DOC17/305677
MP 06 0250 MOD 9

As discussed with you last week, NPWS has been in discussions with the proponent of the Fern Bay residential major project regarding their current project modification application (Modification 9 – MP06_250 MOD9), and specifically the issues raised by NPWS that were yet to be resolved. These issues have been documented in previous correspondence from OEH (ref DOC17/228987-1). The issues raised by NPWS relate to risk to the WCL, commitments already delivered, and commitments still required under the Fern Bay Voluntary Planning Agreement and Deed of Agreement.

SCALE	1: 1000	DRAWING TITLE	STAGES 18 & 19 DETAIL PLAN REV L
REVISION DATE	01/11/2016	DEVELOPMENT	PROJECT PLAN L
PLOT DATE	01/11/2016	DRAWN/CHKD BY	FERM BAY SEASIDE VILLAGE
DA NUMBER		IMC / AED	NELSON BAY ROAD, FERN BAY
		CC NUMBER	CLIENT
			RAWSON COMMUNITIES PTY LIMITED

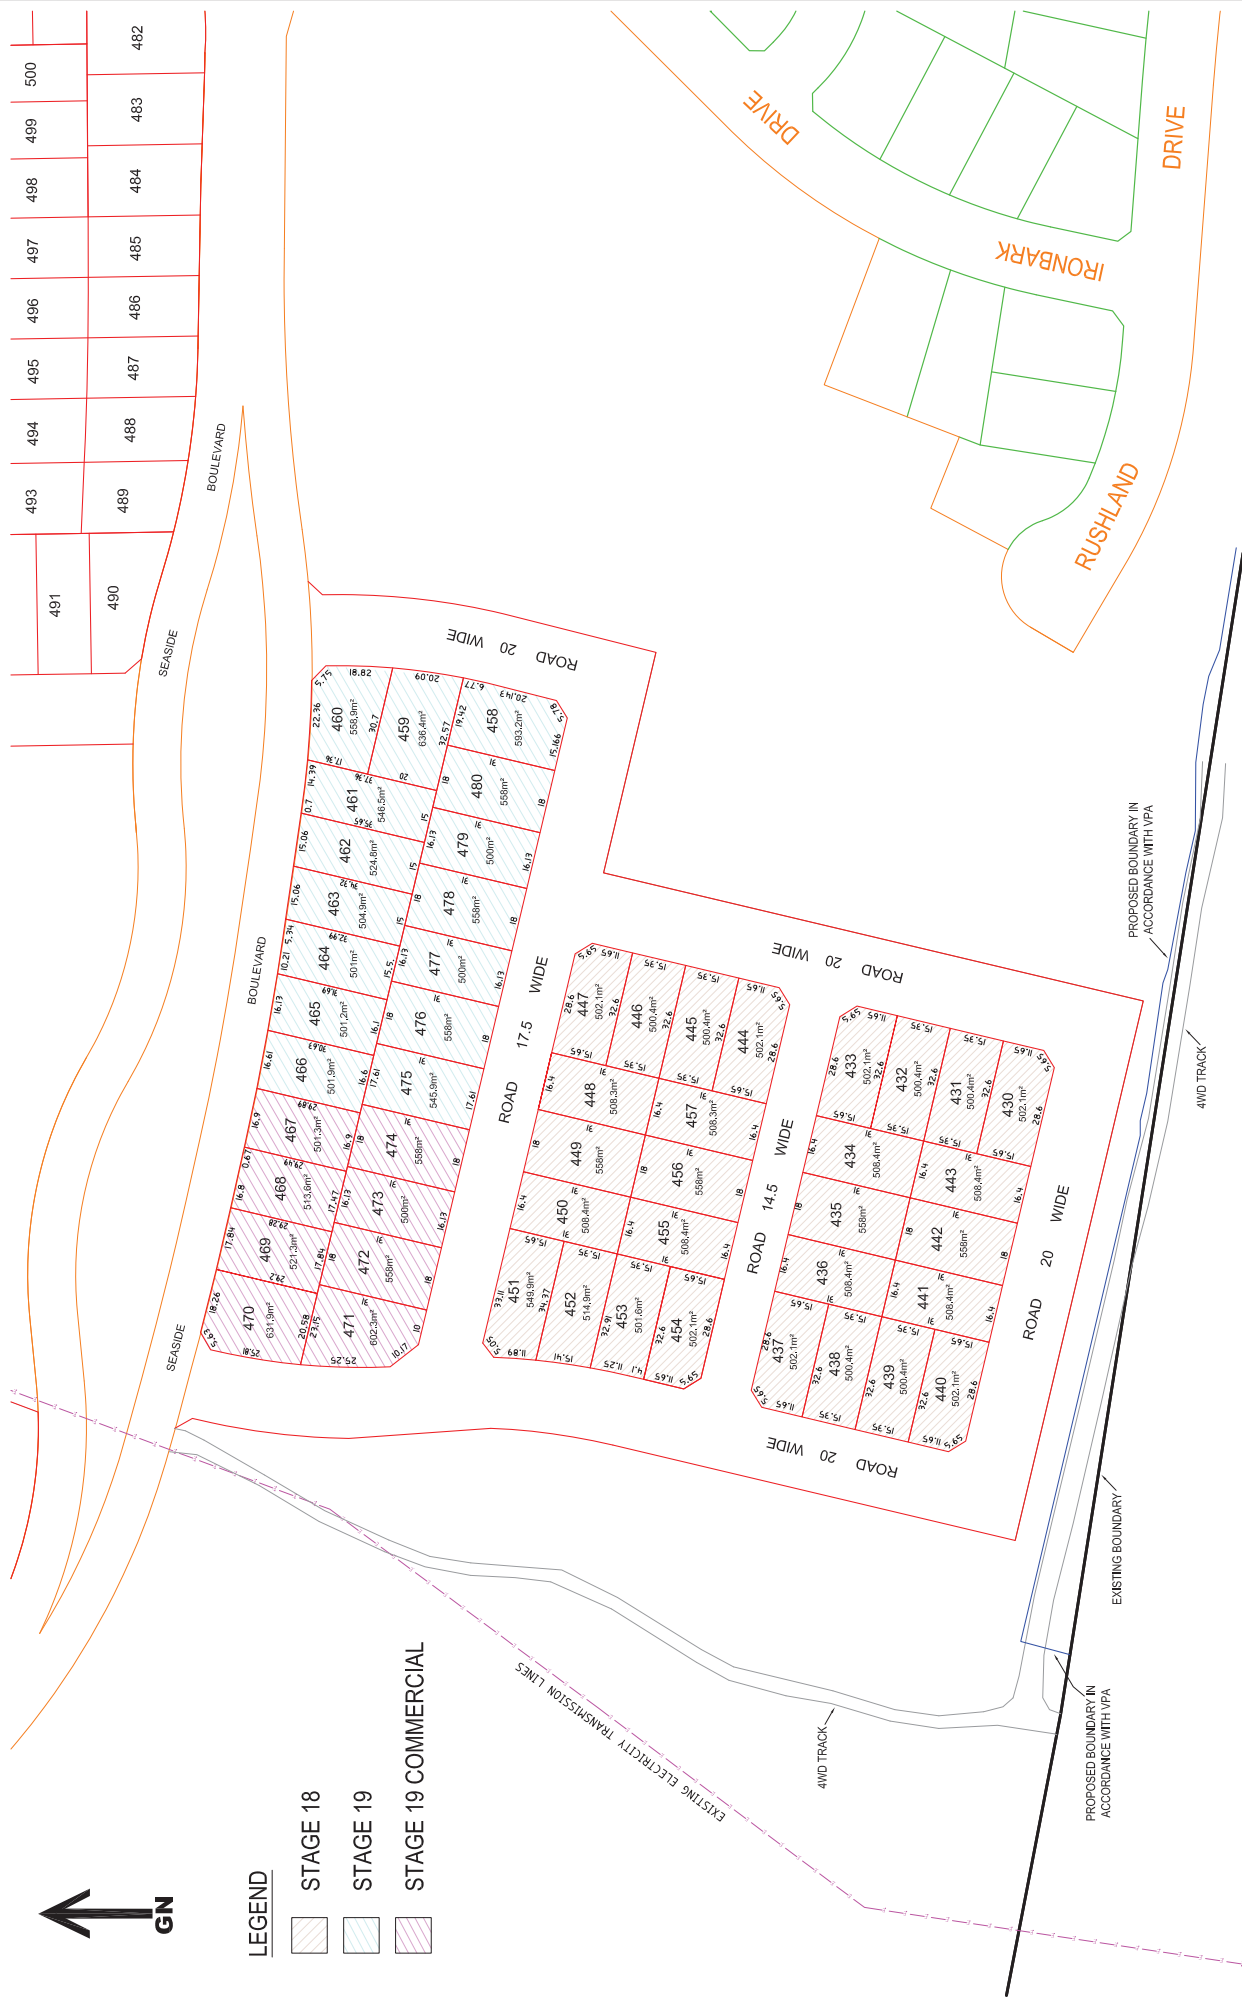
1. *Boundary adjustment inclusion on all plans for stages 18 and 19*
The proposed adjusted boundary with the Worimi Conservation Lands (WCL) needs to be shown on all plans for stages 18 and 19, and should be included as a condition of approval.

2.4 The 4WD track delivered as a requirement of the Fern Bay Voluntary Planning Agreement has been designed and constructed so that stormwater runoff drains across the proposed boundary and onto the development site. The stormwater design for stages 18 and 19 must account for this existing situation, and the landscaping must be designed to ensure no impact on the 4WD track (including the bollard and cabling along the 4WD track) or land within the proposed WCL boundary due to stormwater runoff.

3. *Stormwater conveyance impacts and ongoing access from Seaside Boulevard to the WCL*
To ensure no impact on the access track from Seaside Boulevard to the 4WD track, stormwater from stages 18 and 19 is to be conveyed in a culvert under the access track. The culvert must be of a capacity exceeding that required for the stormwater system as currently designed. This condition is to be satisfied by the proponent prior to issue of a subdivision certificate for stages 18 and 19.

4. *Access to the 4WD track*
A hard barrier is to be installed between the access to the 4WD track and stages 18 and 19, in the form of bollard and cabling along the access to the 4WD track from Seaside Boulevard. This condition is to be satisfied by the proponent prior to issue of a subdivision certificate for stages 18 and 19.

PROPOSED RETAINING WALL

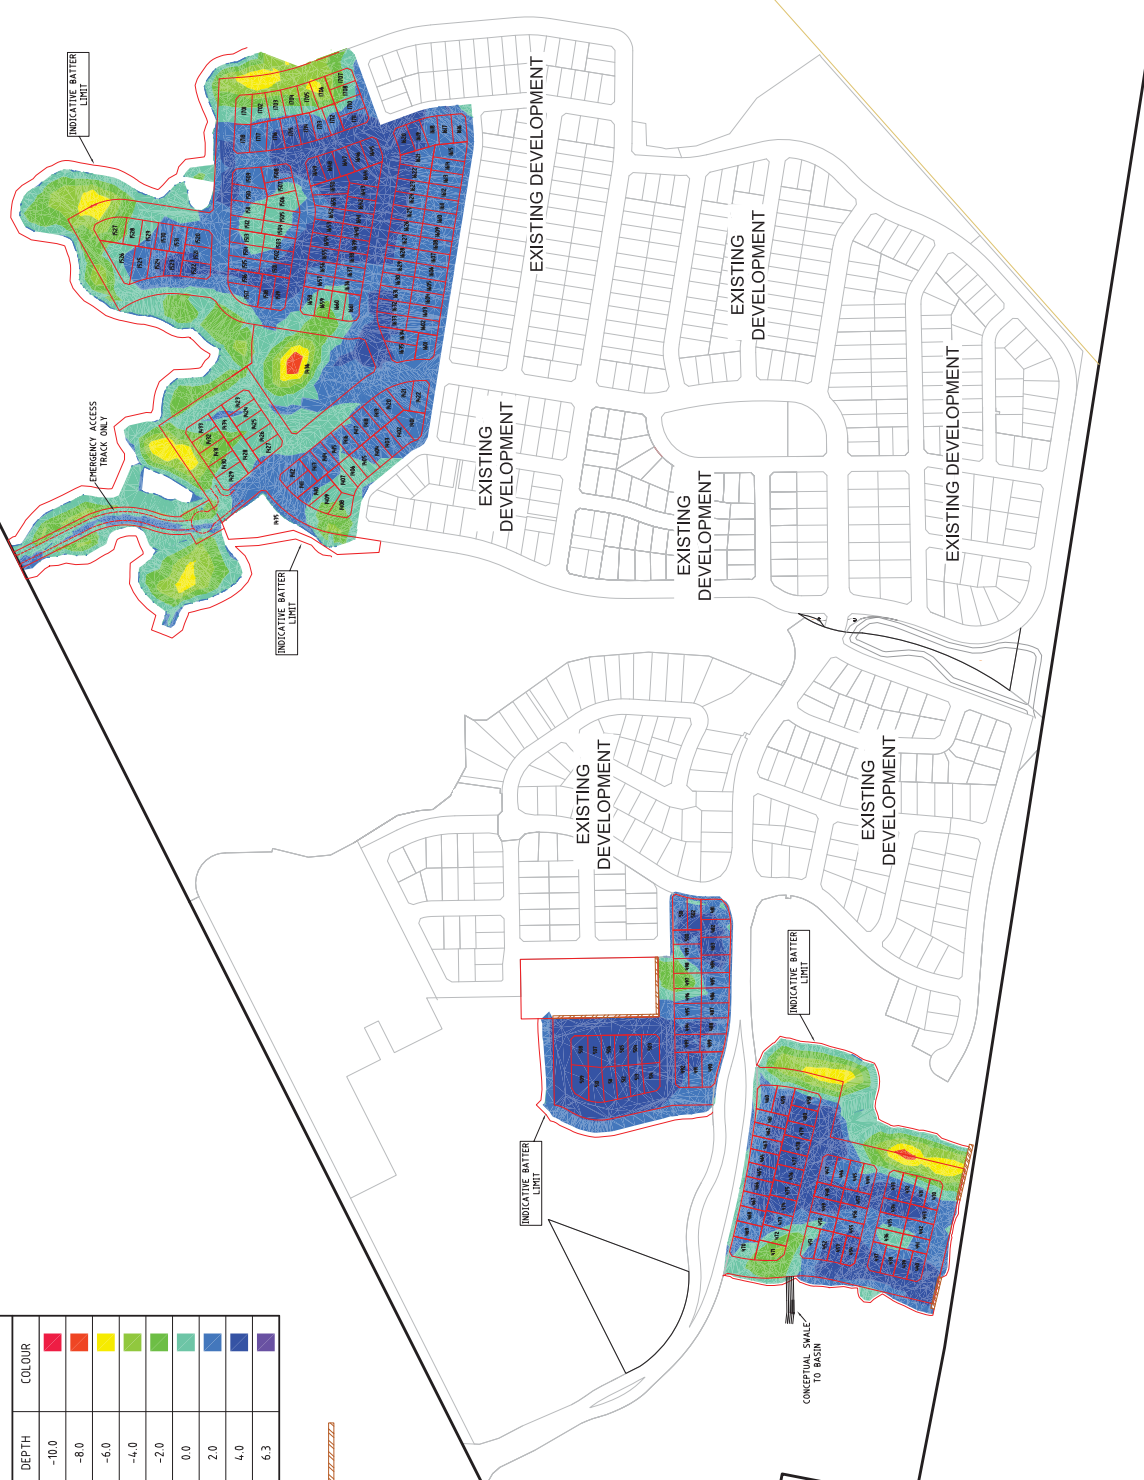
- 2.1 The retaining wall to be located in stage 18 (as shown in drawing 21 of 21 "Bulk earthworks (cut-fill) plan in document 2016-11-10 34878 Project Plan Rev L) adjacent to the 4WD track and proposed WCL boundary must be contained wholly within the development site, and any land required for the maintenance of the retaining wall must be wholly contained within the development site, and not within the proposed WCL boundary.

- 2.3 The ground level next to the 4WD track bollard line must be maintained at its current height at a minimum distance of 0.6m and greater where possible, beyond which the batter slope must not be steeper than a gradient of 1 metre height change for every 6 metres in distance.
